3 November 2009

**Reference: MOORE THEOLOGICAL COLLEGE, 1 KING STREET NEWTOWN  
BUILDING CODE OF AUSTRALIA COMPLIANCE STATEMENT**

Figure PA 2001: Basement level 1 plan

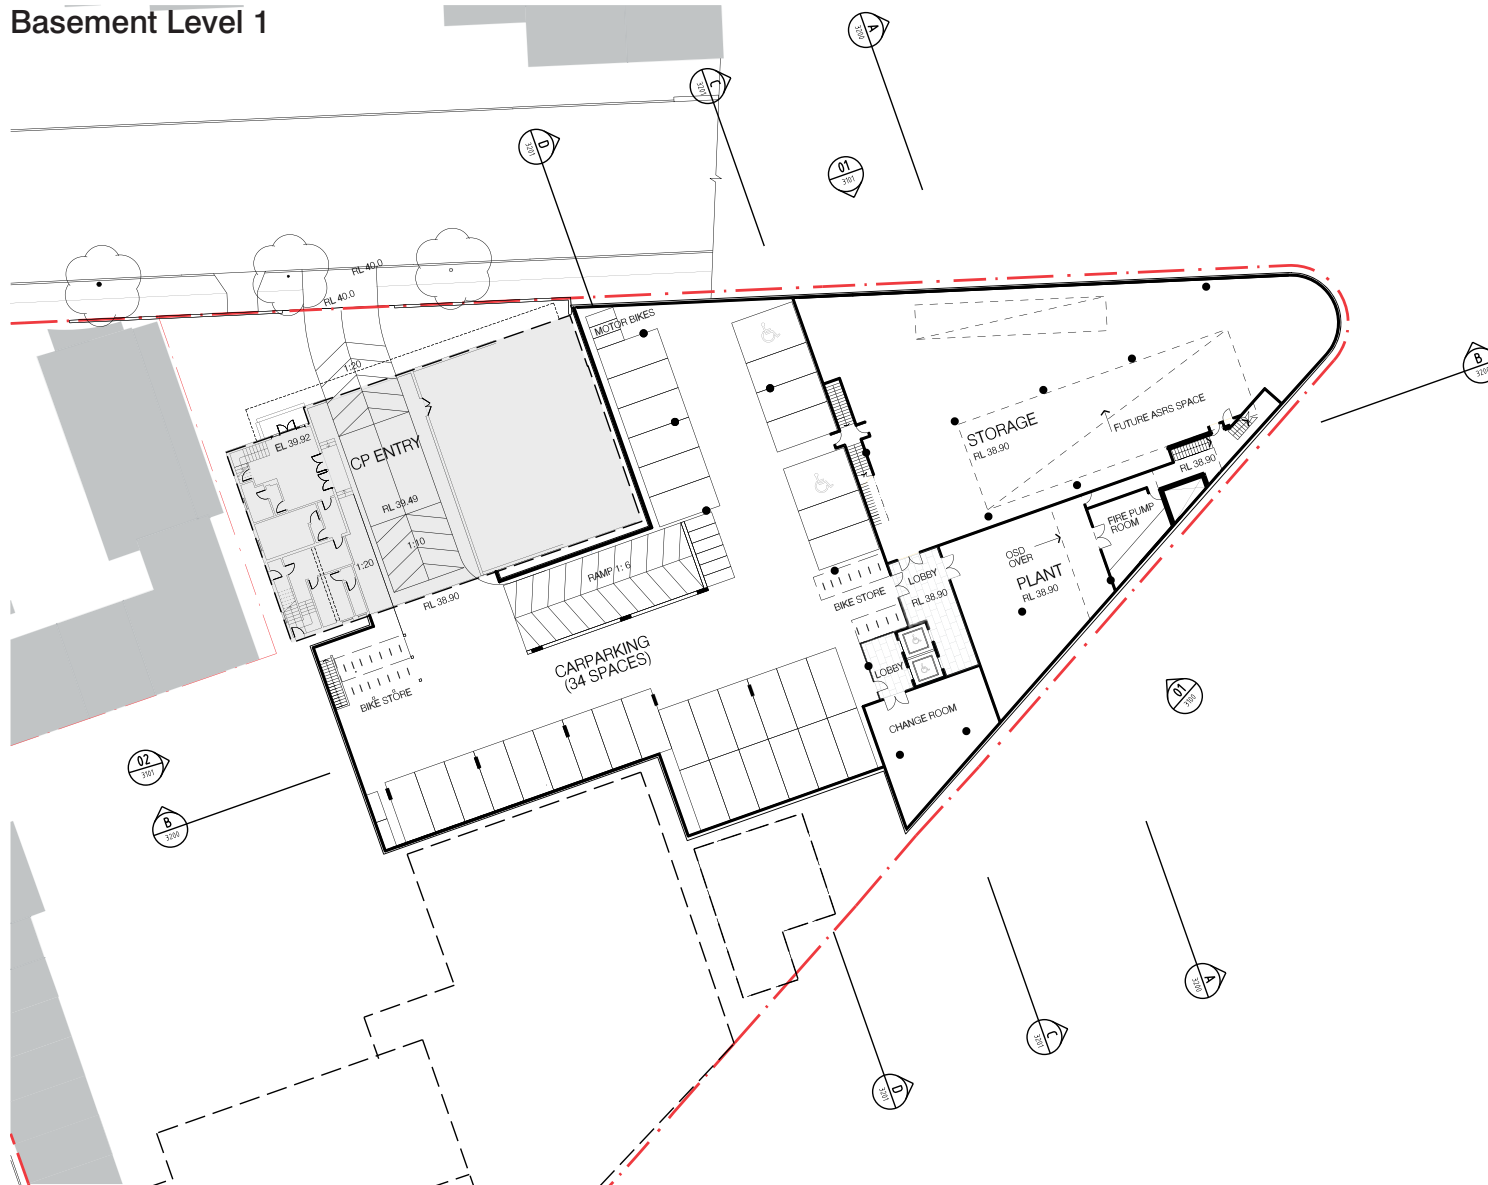
In this regard, we note that there may be excessive travel distance non compliances located within the basement carparking levels. A further assessment of the travel distances will be carried out to determine compliance, prior to the issuing of the Construction Certificate.

Figure PA 2101: Ground level 1 plan

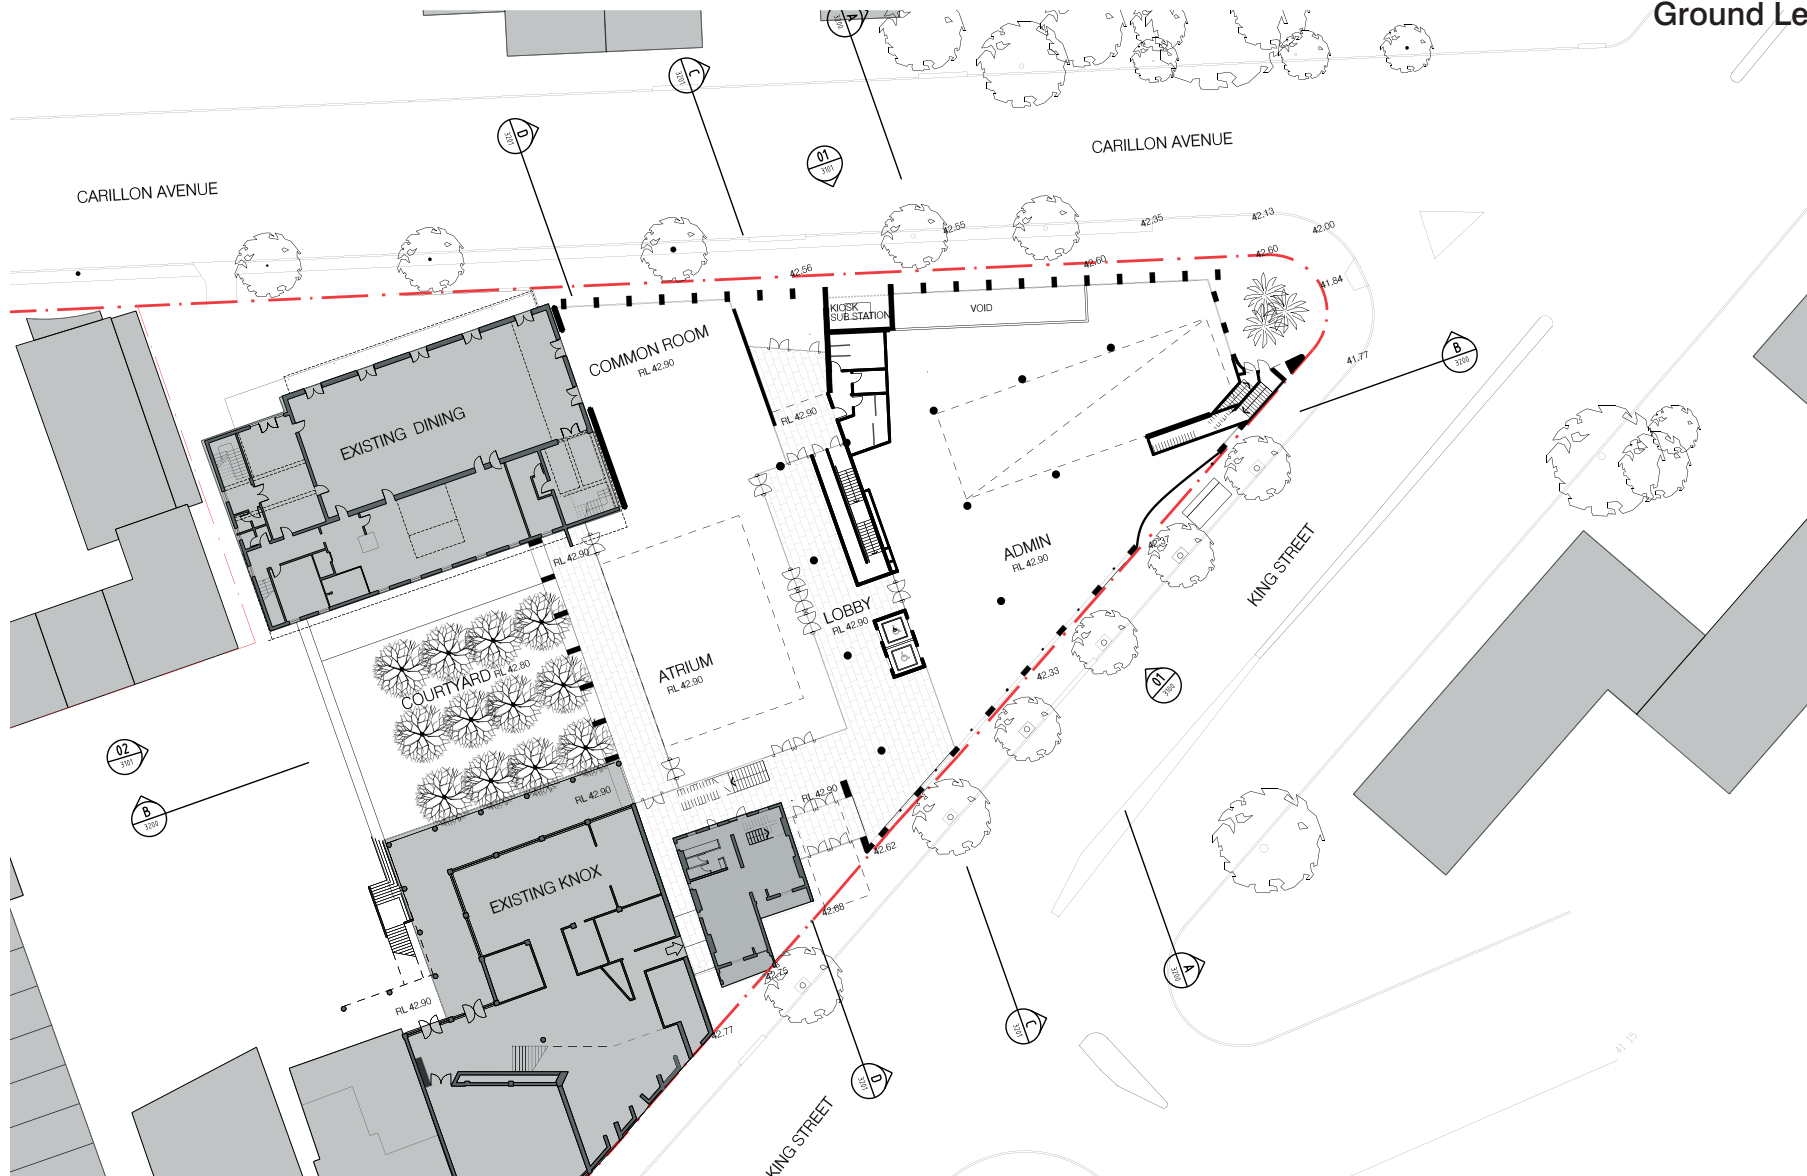
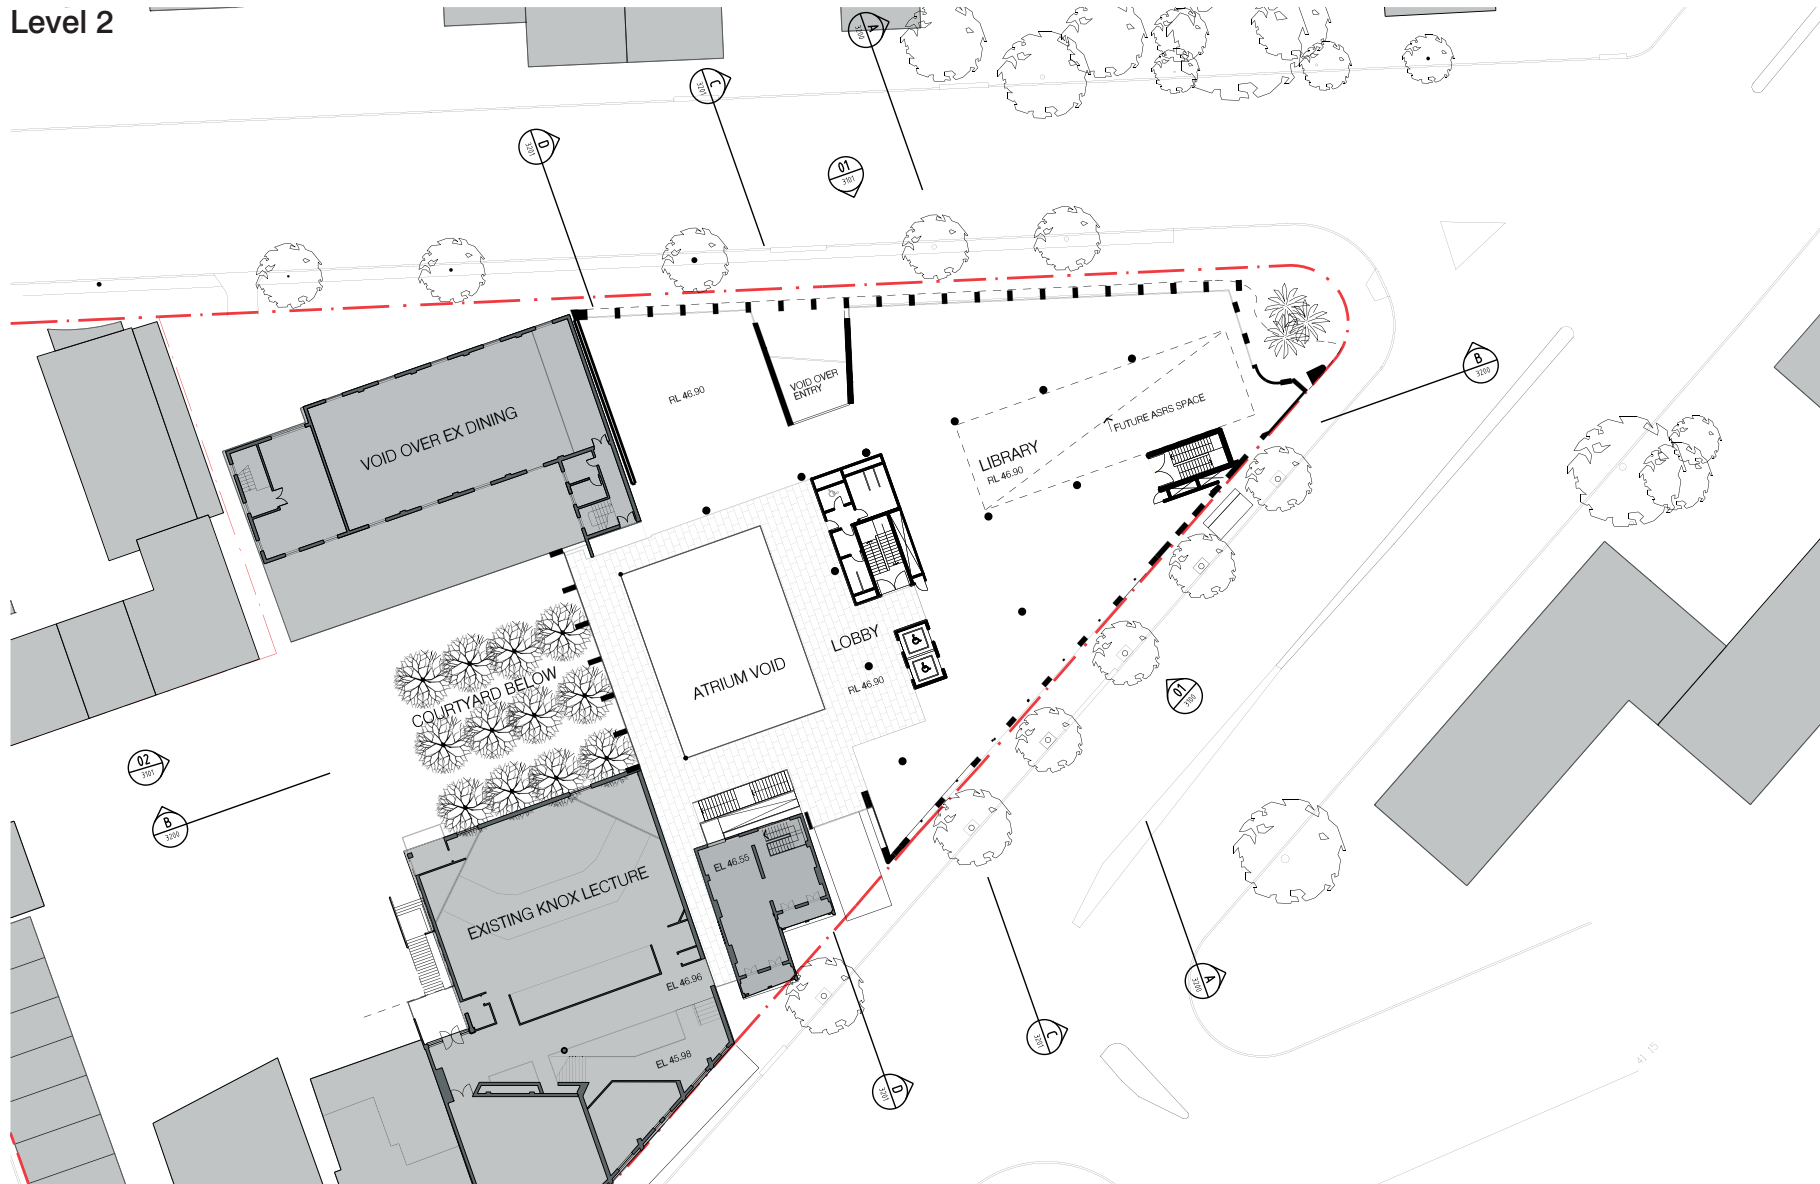
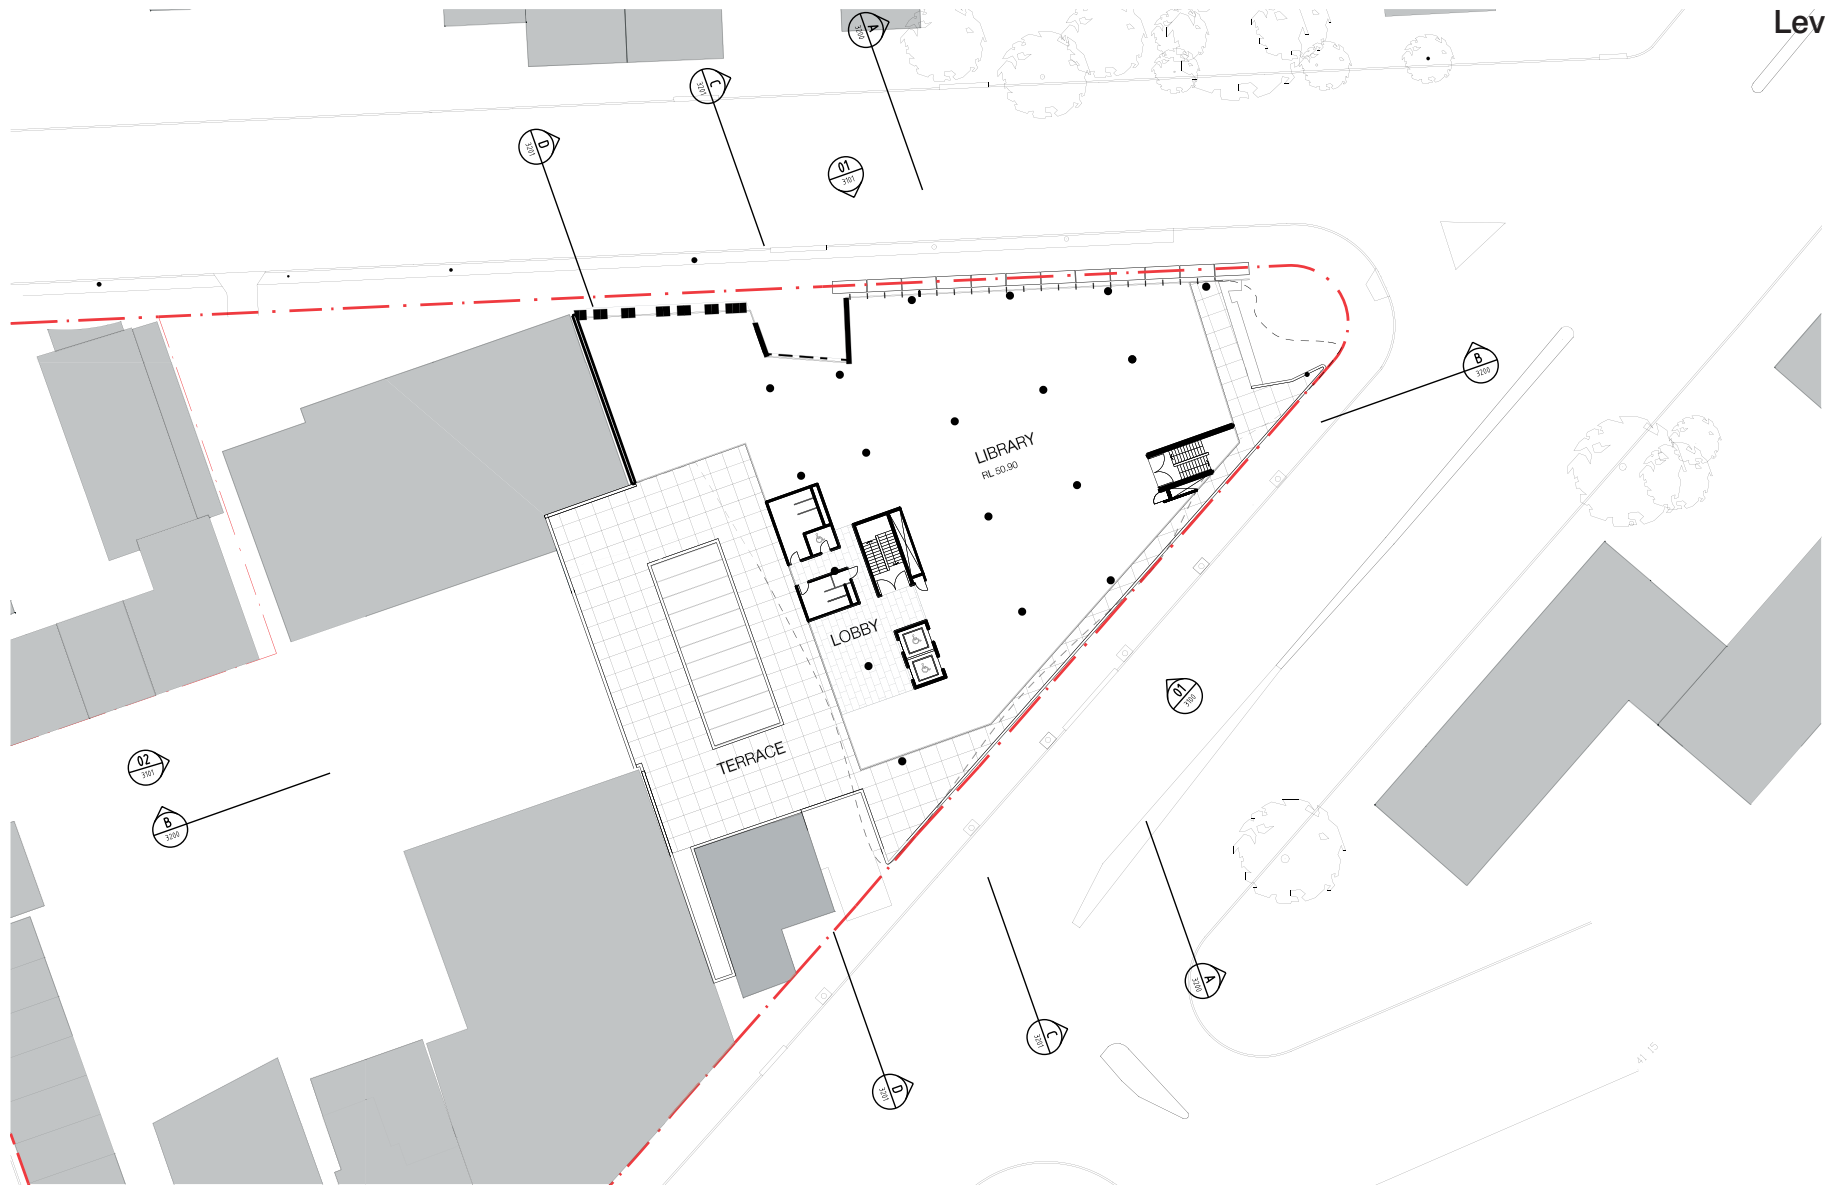
17. The northern fire isolated stairway serving the upper storeys appears to contain glazed construction located within the external walls of the stairway. In this regard we note that openings located in a fire isolated stairway must not be exposed to other window openings located in the external wall of the building within a distance of 6m. Subject to minor plan amendments the stair can readily achieve compliance.
